**From:** Lauren McMahon <lmcmahon@mecone.com.au>  
**Sent:** Wednesday, 1 November 2017 1:32 PM  
**To:** Aditi Coomar  
**Subject:** Re: Modification to Redevelopment of Parramatta Public and Arthur Phillip High Schools - Request additional information  
**Attachments:** Re: APHS: s96 modification of material to the gym

**Subject:** Modification to Redevelopment of Parramatta Public and Arthur Phillip High Schools - Request additional information

I refer to the above application and advise that the proposed modification has been referred to EPA, OEH, Parramatta Council and Heritage Council for comments. Consequently, the following information is requested by the Department and by EPA prior to further assessment being undertaken:

1 CONTEXT\_ELEVATION\_EAST  
1 : 500

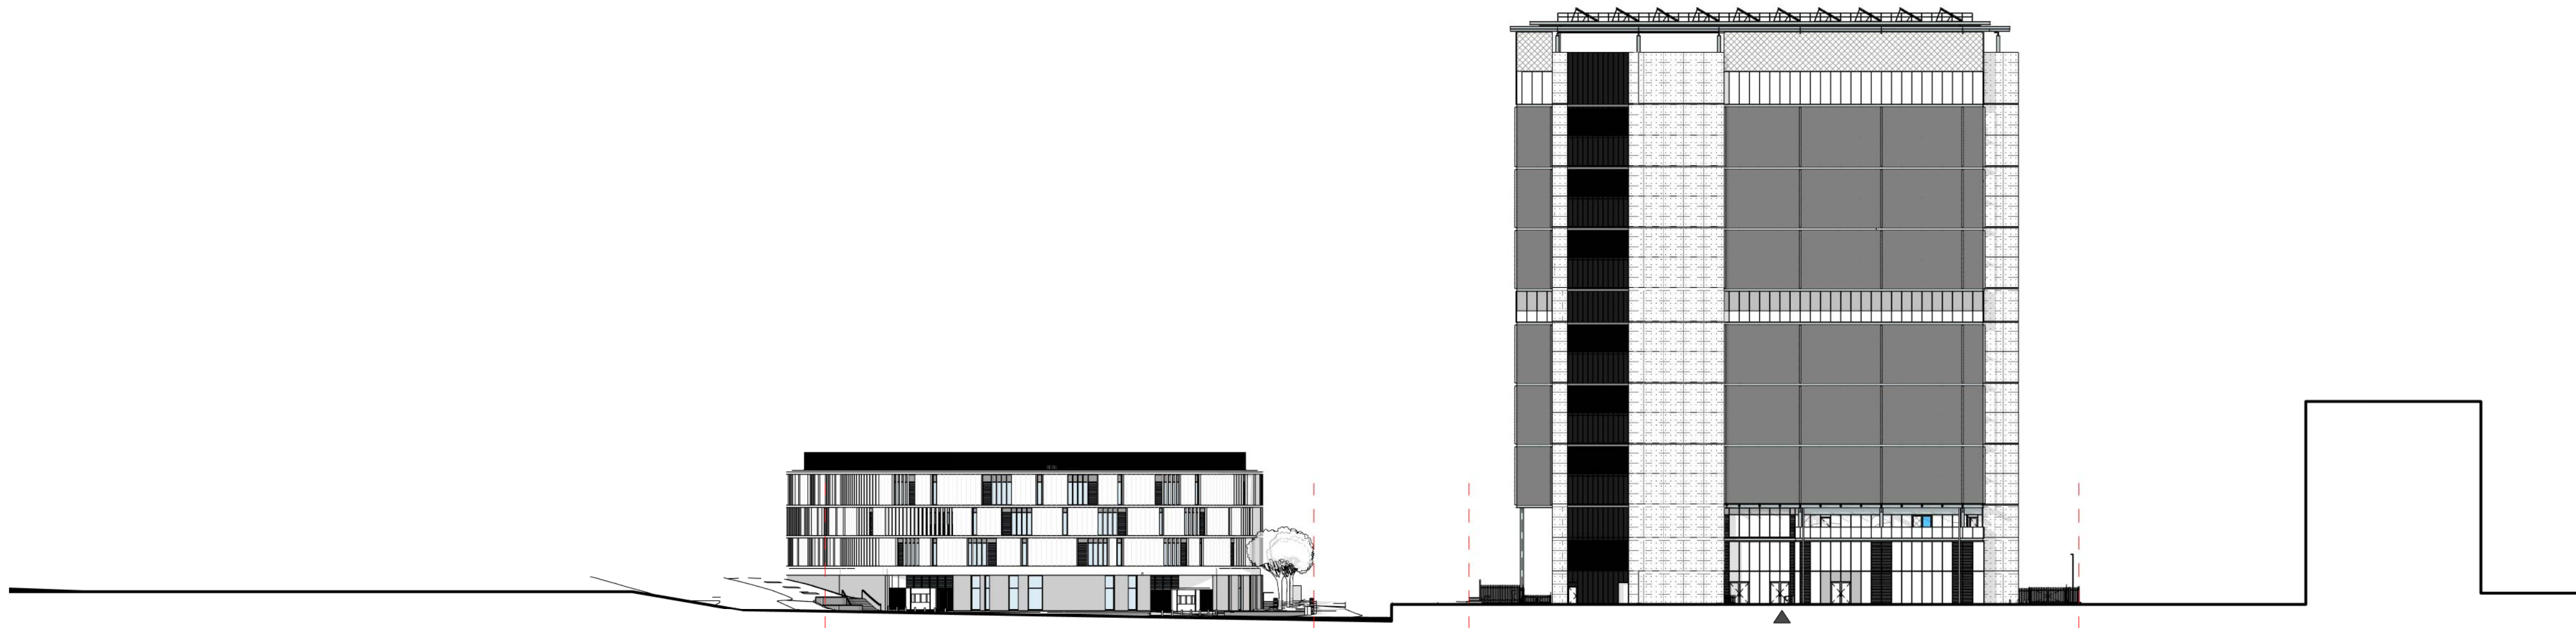
The submitted drawings (east elevation) indicates that the materials for the PPS is being changed from brick to Terracotta GFRC. However, the list of modifications do not include this amendment. You are requested to clarify this matter. **The response to submissions package sent to DP&E in September 2016 outlined the proposed changes to the materials for the PPS and APHS which were a result of the Design Jury comments. Please see the extract form Appendix 12 – Design Intent report of the package below. The extract outlines that the terracotta coloured fibre cement was to be reinstated to the PPS as per the competition scheme.**

DRAWING  
ELEVATIONS APHS - WEST  
ELEVATION

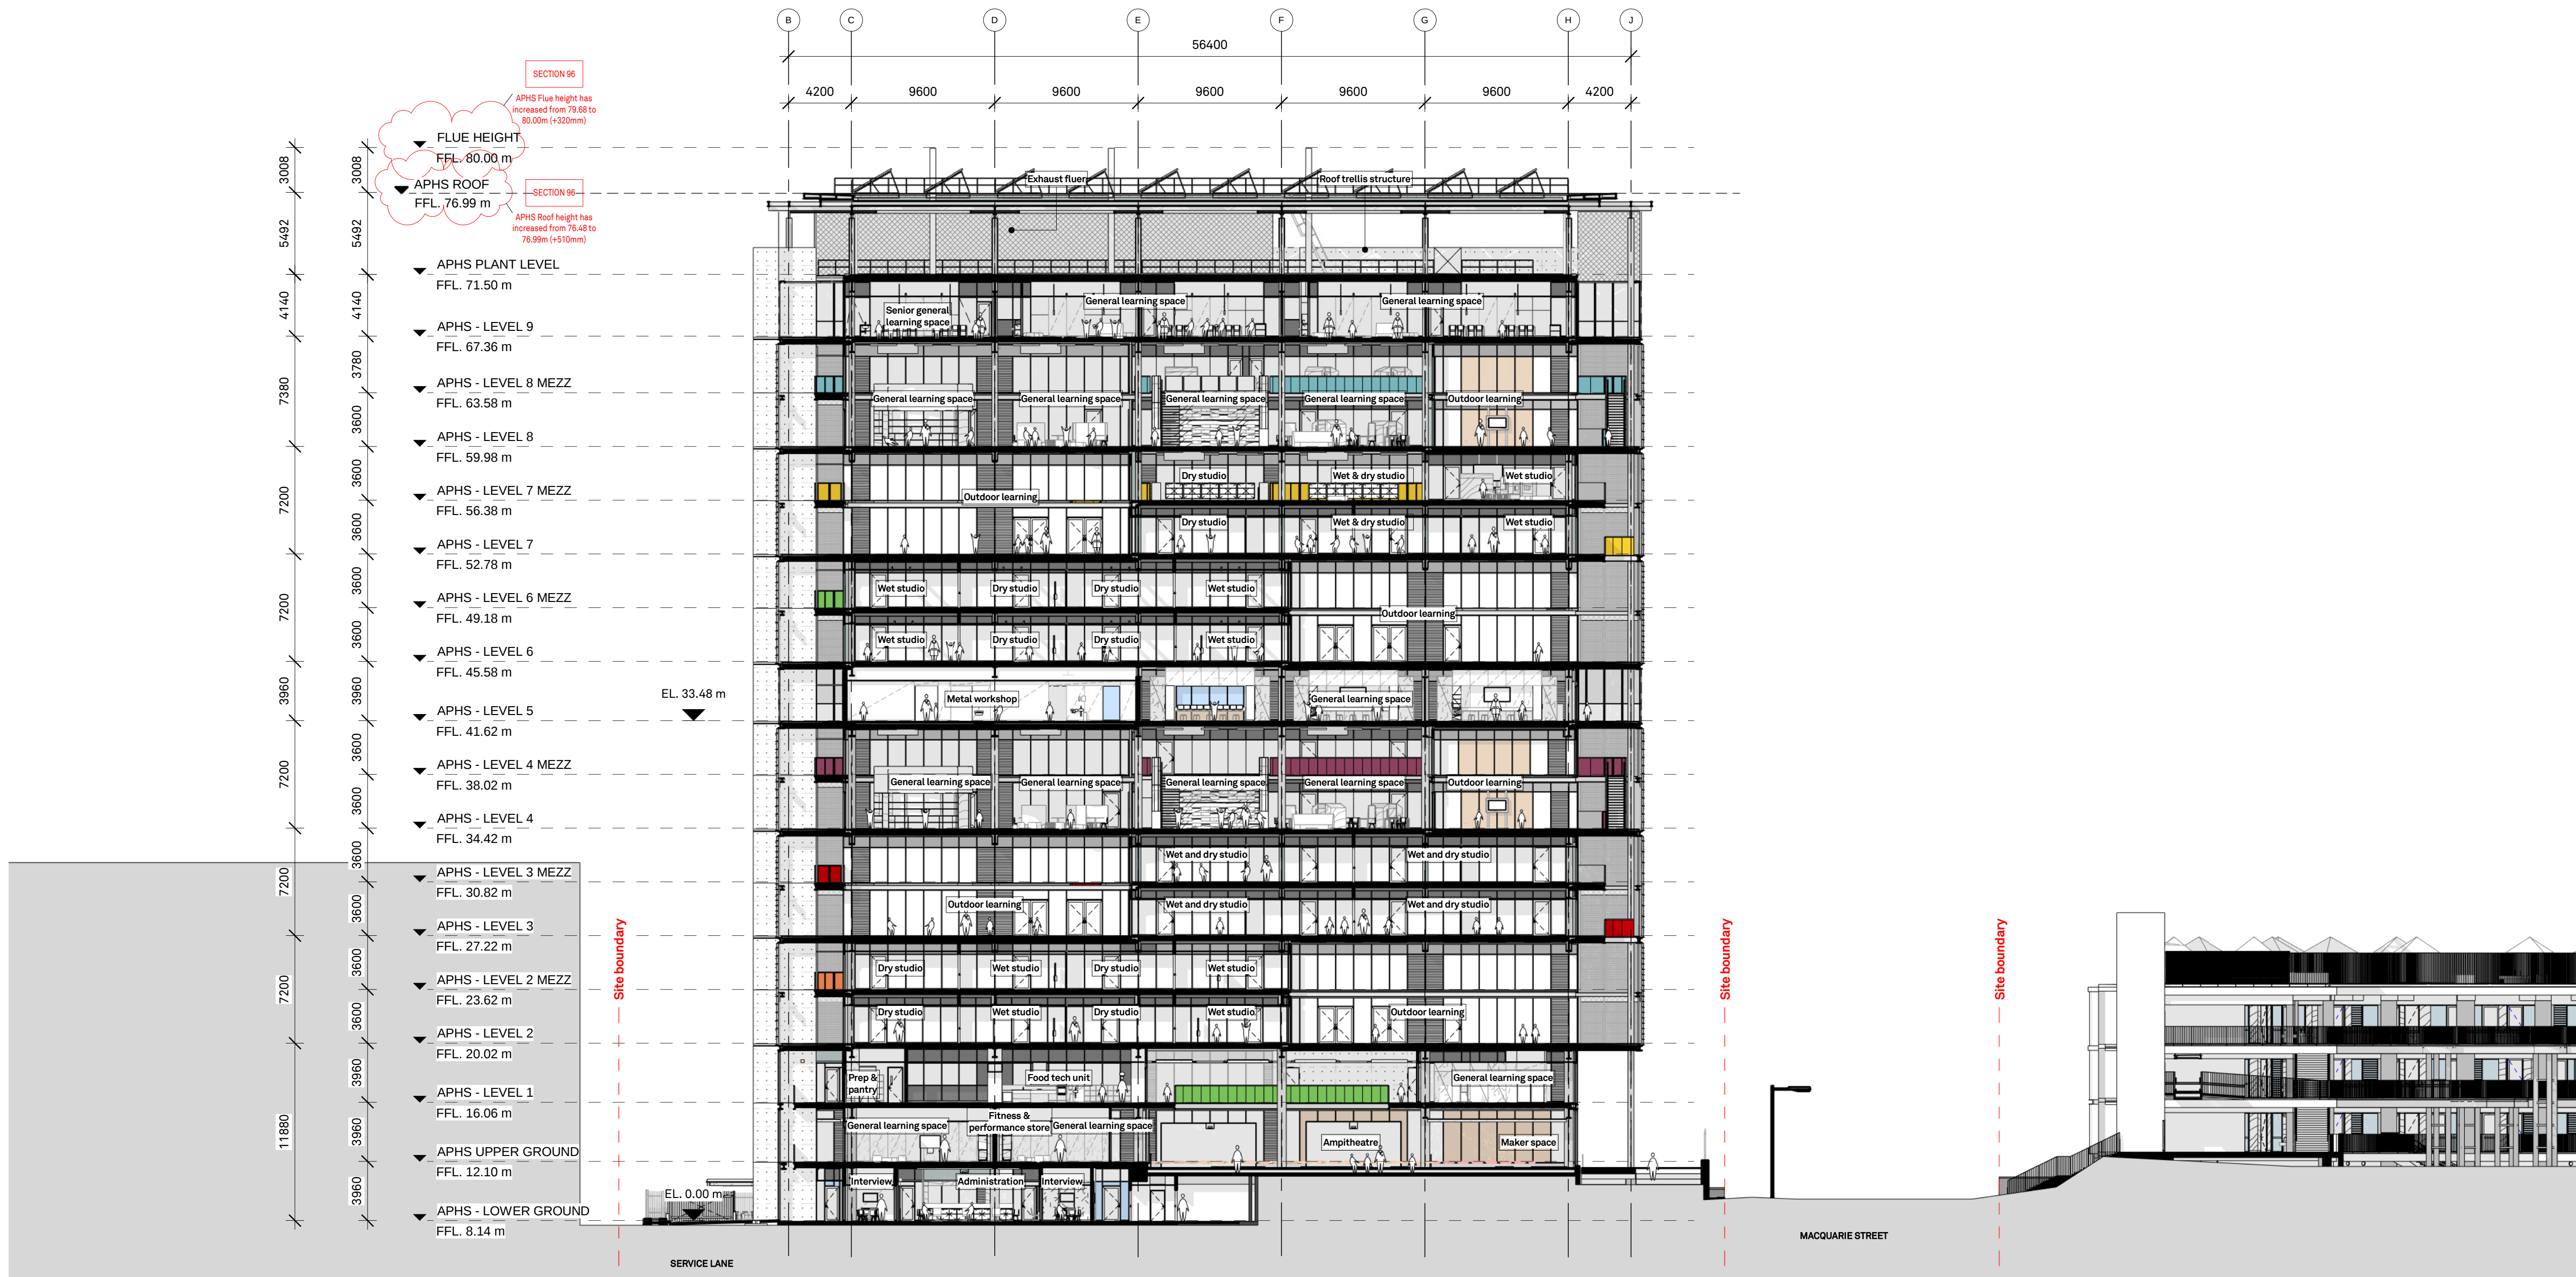
(a) substituting metal for masonry cladding of part of the Arthur Phillip High School gymnasium which may influence the character, quality and level of noise impacts on

surrounding noise sensitive land uses, particularly during use of those facilities outside school hours, and Our Acoustic Consultants (ARUP) have looked at the amendments to the material to the APHS gym, see attached correspondence. ARUP states that the noise levels at the nearest external receiver meet the project criteria.

Based on our conversation today, I understand that the section of façade highlighted below is being changed from masonry to lightweight construction.

- 1) Noise breakout from the spaces adjoining that façade on the Upper Ground level aren't of concern, given the intended usage (Store rooms, First Aid).
- 2) We've updated our noise breakout calcs for the plantroom adjoining that façade on Level 1, incorporating the proposed façade build-up (4mm metal sheet | 248mm cavity with 50mm fibreglass insulation (18kg/m<sup>3</sup>) | 13mm plasterboard). Noise levels at the nearest external receiver meet the project criteria.

So the proposed lightweight façade construction is acceptable.
